Ribble Valley Borough Council
Council Offices
Church Walk,
Clitheroe
Lancashire
BB7 2RA

Phone: 0300 123 6780
Email: developeras@lancashire.gov.uk
Your ref: 3/2026/0204
Our ref: 3/2026/0204/HDC/KW
Date: 09 September 2026

Location: Proposed new agricultural field gate and entrance.
Proposal: Land adj to Coulthurst Old Vicarage Lane Talbot Bridge Bashall Eaves
BB7 3DB
Grid Ref: 369851 443544

Summary

PL04: Proposed Visibility Splay – Not to scale.

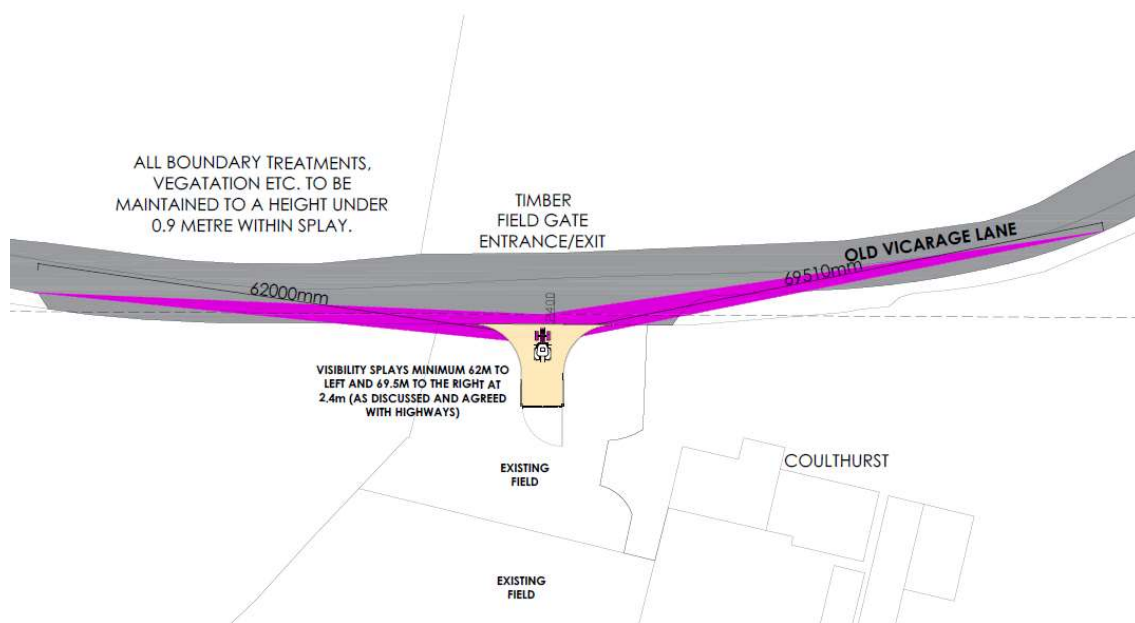
The applicant has also submitted visibility splays, drawing 6880 P03A, which show achievable visibility splays of 69 metres to the North and 62 metres to the South. The visibility splay shall be wholly within the land which the applicant controls and/or the adopted highway and nothing shall be erected, retained, planted and / or allowed to grow at or above a height of 0.9 metres above the nearside carriageway level which would obstruct the visibility splay of the proposed access.

As such, the LHA is of the view that vehicle speeds along Old Vicarage Lane are lower than the posted speed limit, which is supported by on-site observations. The achievable visibility splays of 62m to the North and 69 meters to the South are therefore acceptable in this case.

2. Before the access is used for vehicular purposes visibility splays 2.4 metres back from the centre line of the access and extending 69 meters to the North and 62m to the South along the nearside carriageway edge have been provided at the access, as shown on the approved plans. Nothing shall be erected, retained, planted and / or allowed to grow at or above a height of 0.9 metres above the nearside carriageway level which would obstruct the visibility splay. The visibility splays shall be maintained free of obstruction at all times thereafter for the lifetime of the development.

6880 - P02A

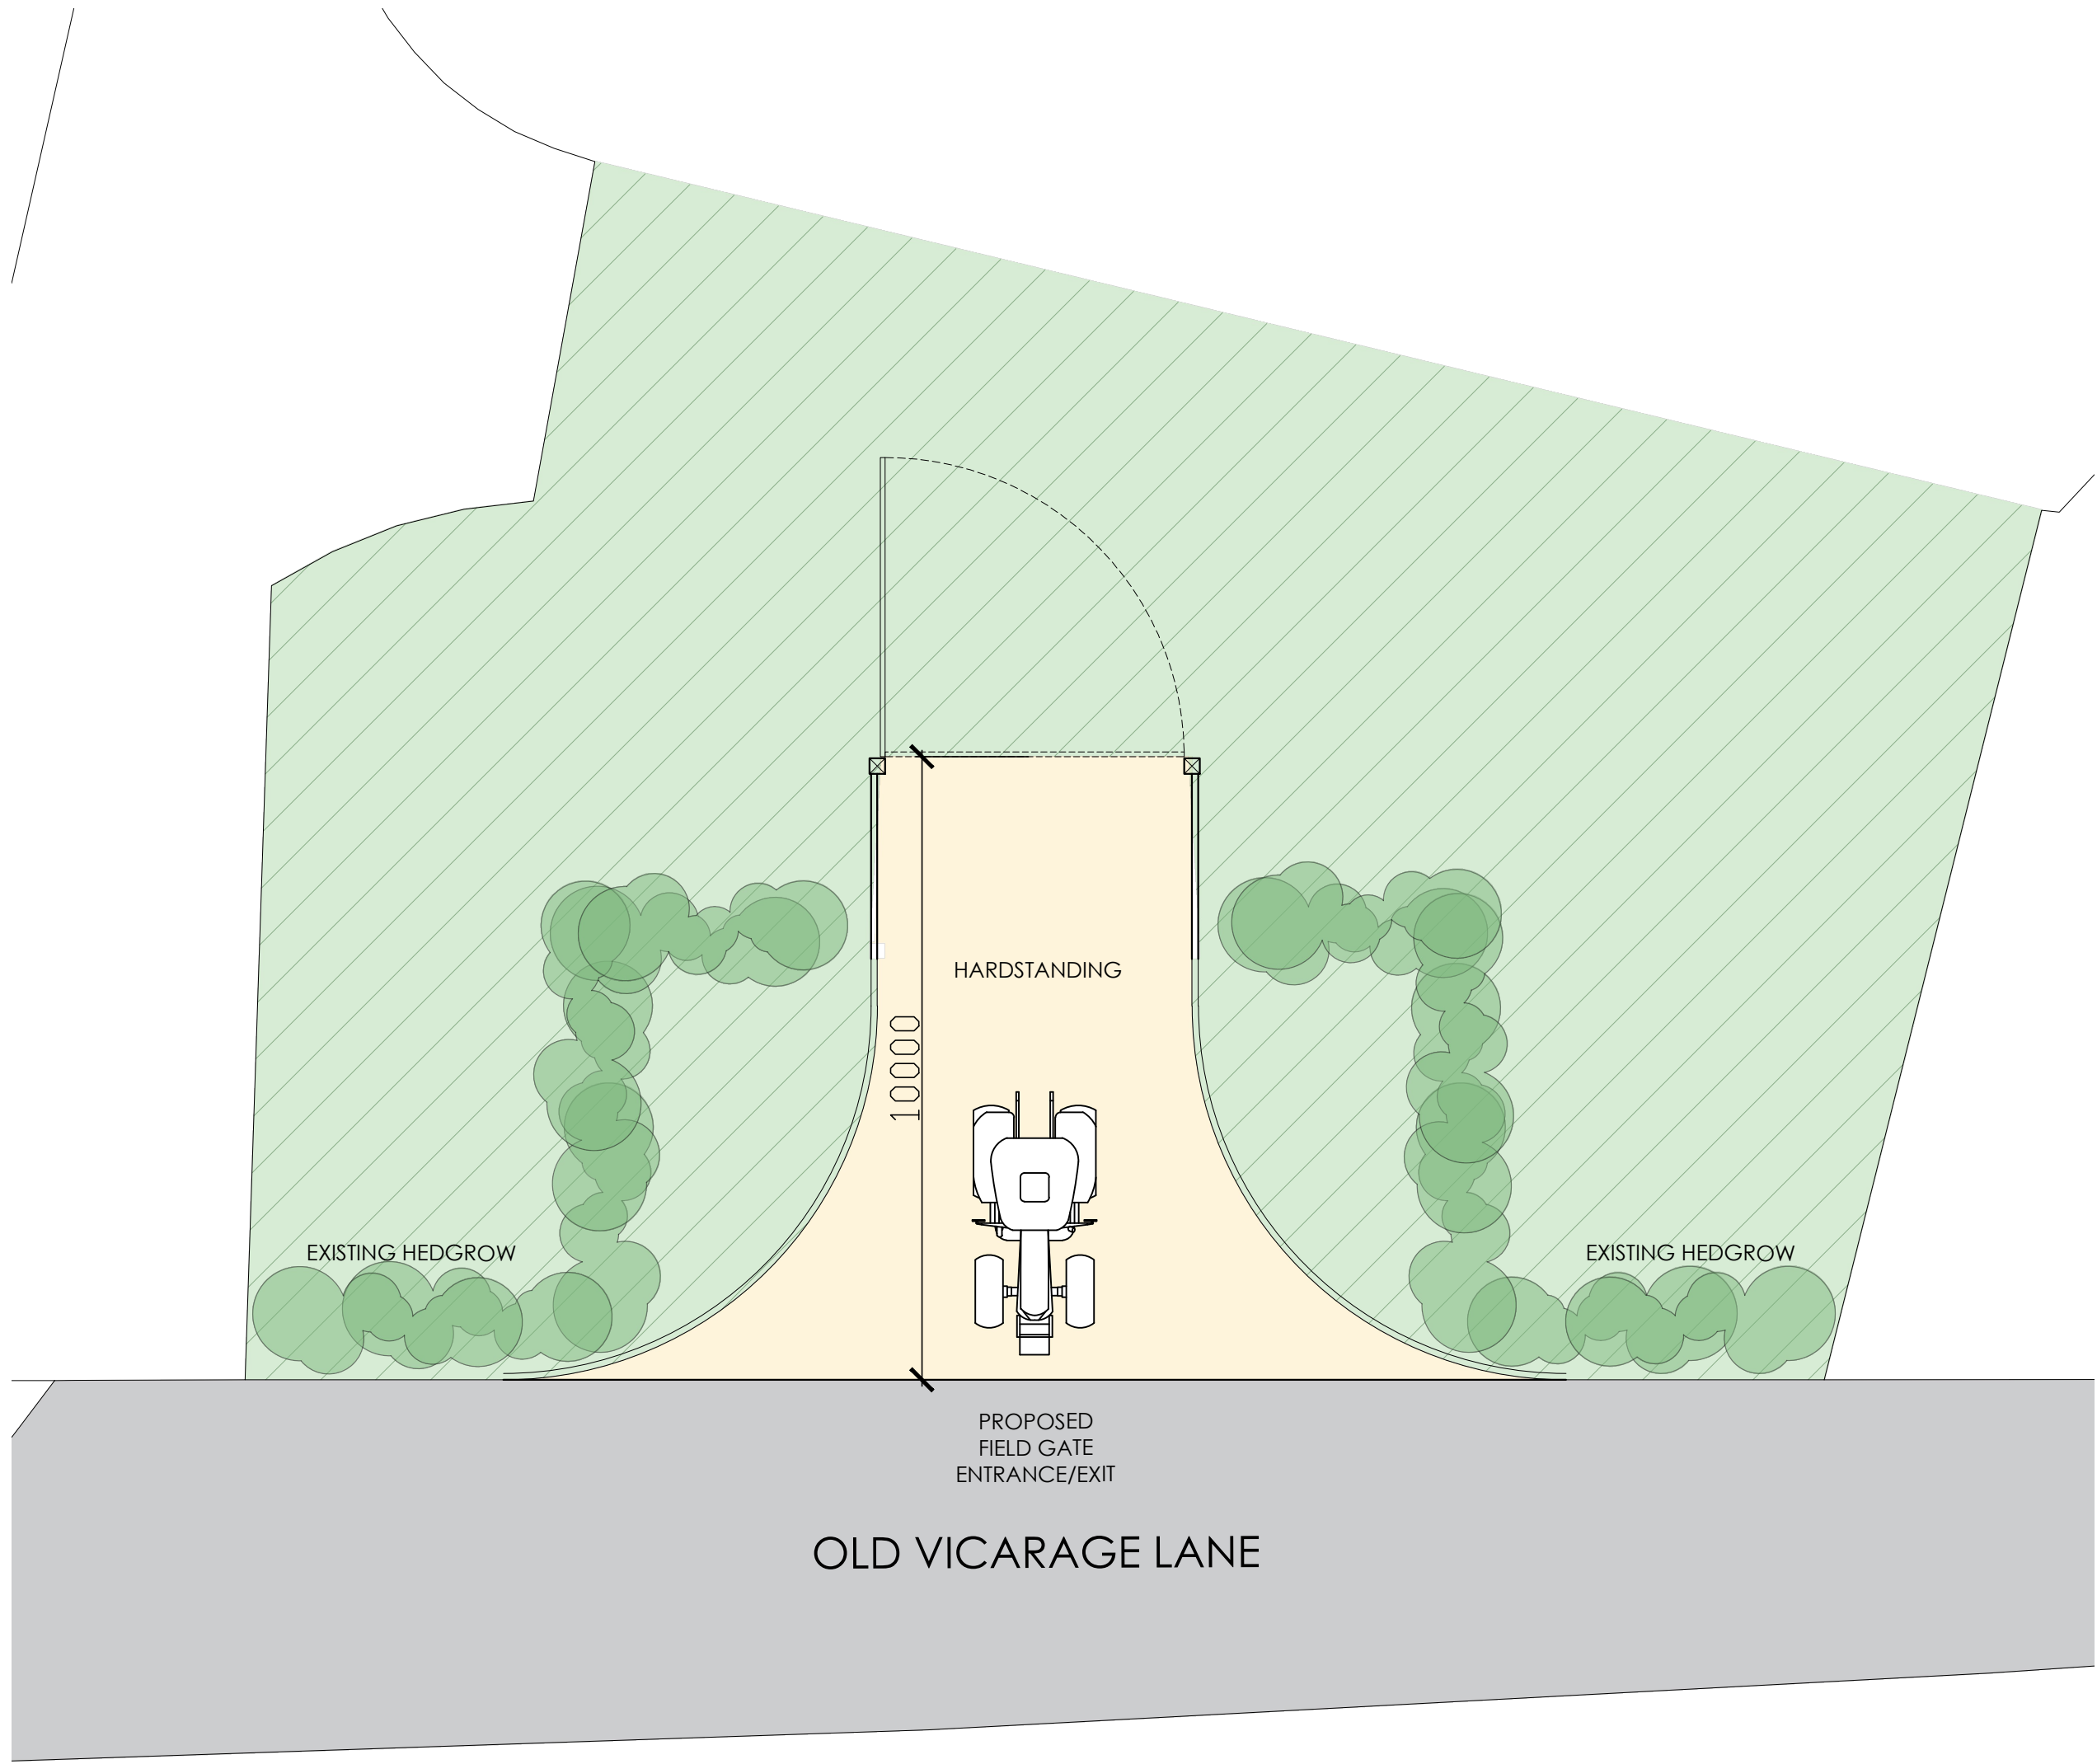
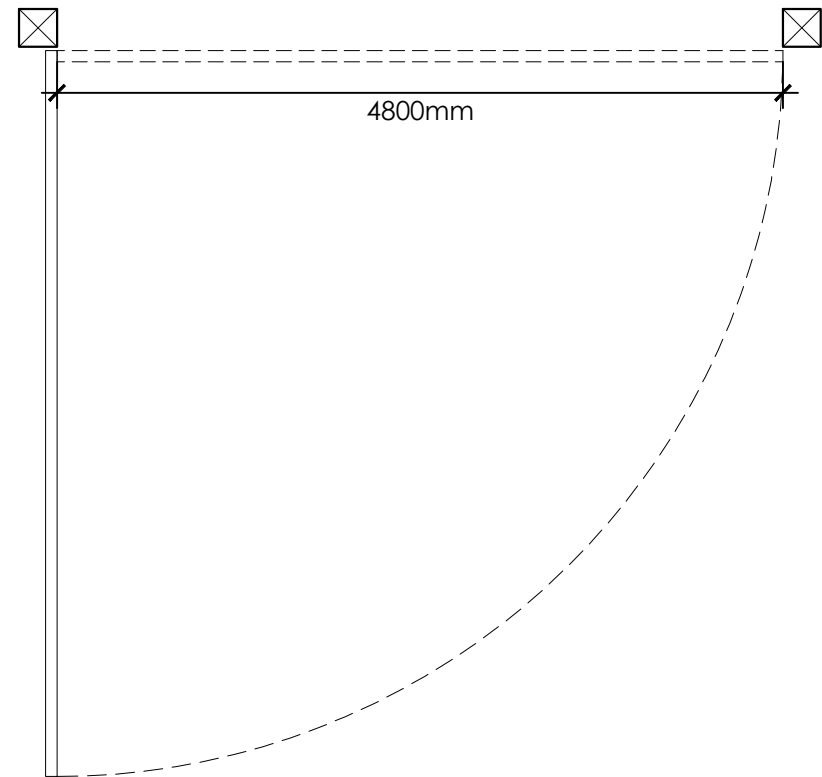
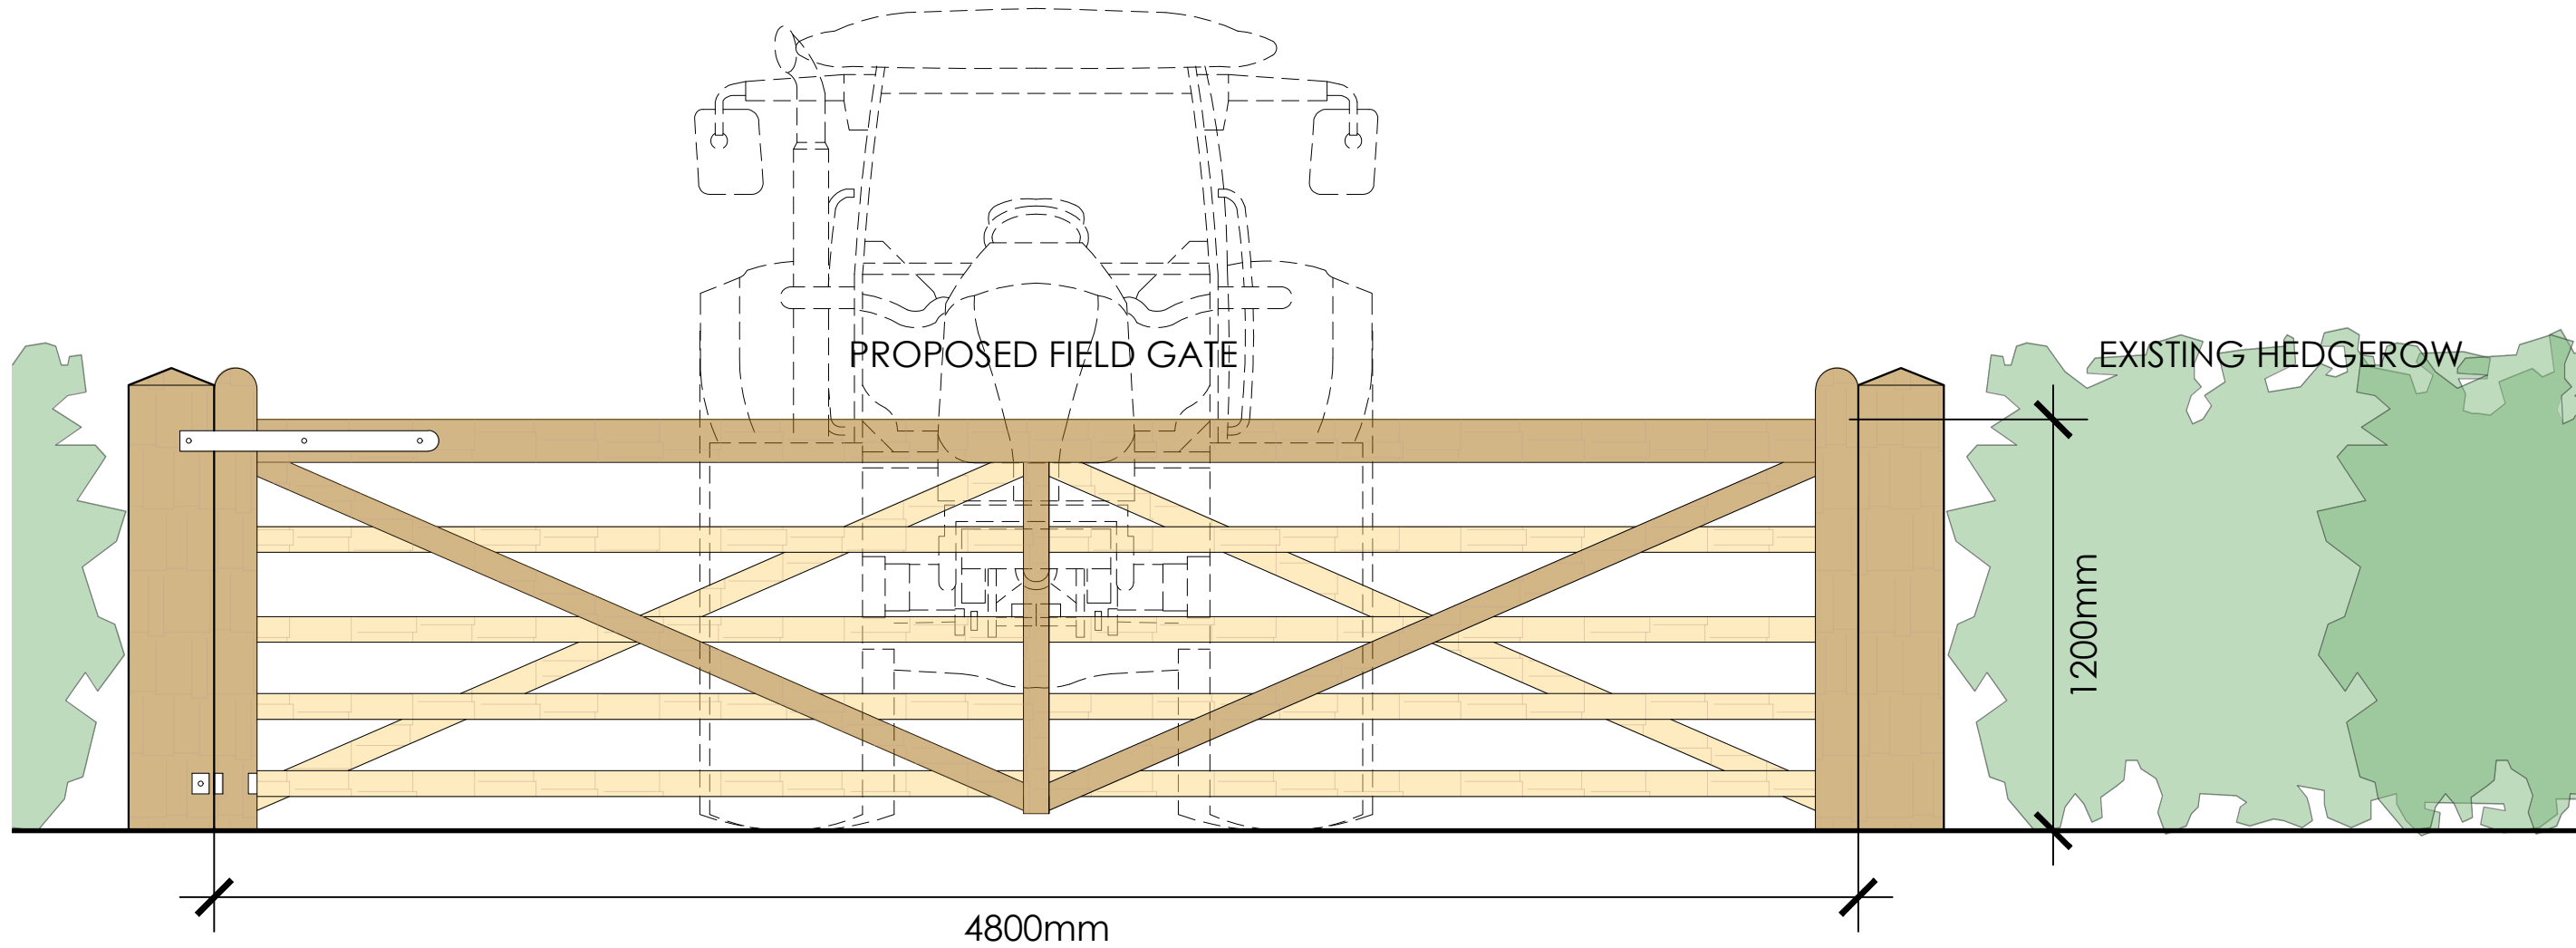
The LHA has reviewed the proposed site plan which shows the access will be surfaced in a hardstanding material for at least 10m behind the carriageway edge and the proposed gate shall be set back 10m into the site. This will ensure no debris is transported onto the highway, and agricultural vehicles can be clear of the carriageway before operating the gate.

4. Before the access is used for vehicular purposes, any gateposts erected at the access shall be positioned 10m behind the nearside edge of the highway. The gates shall open away from the highway.
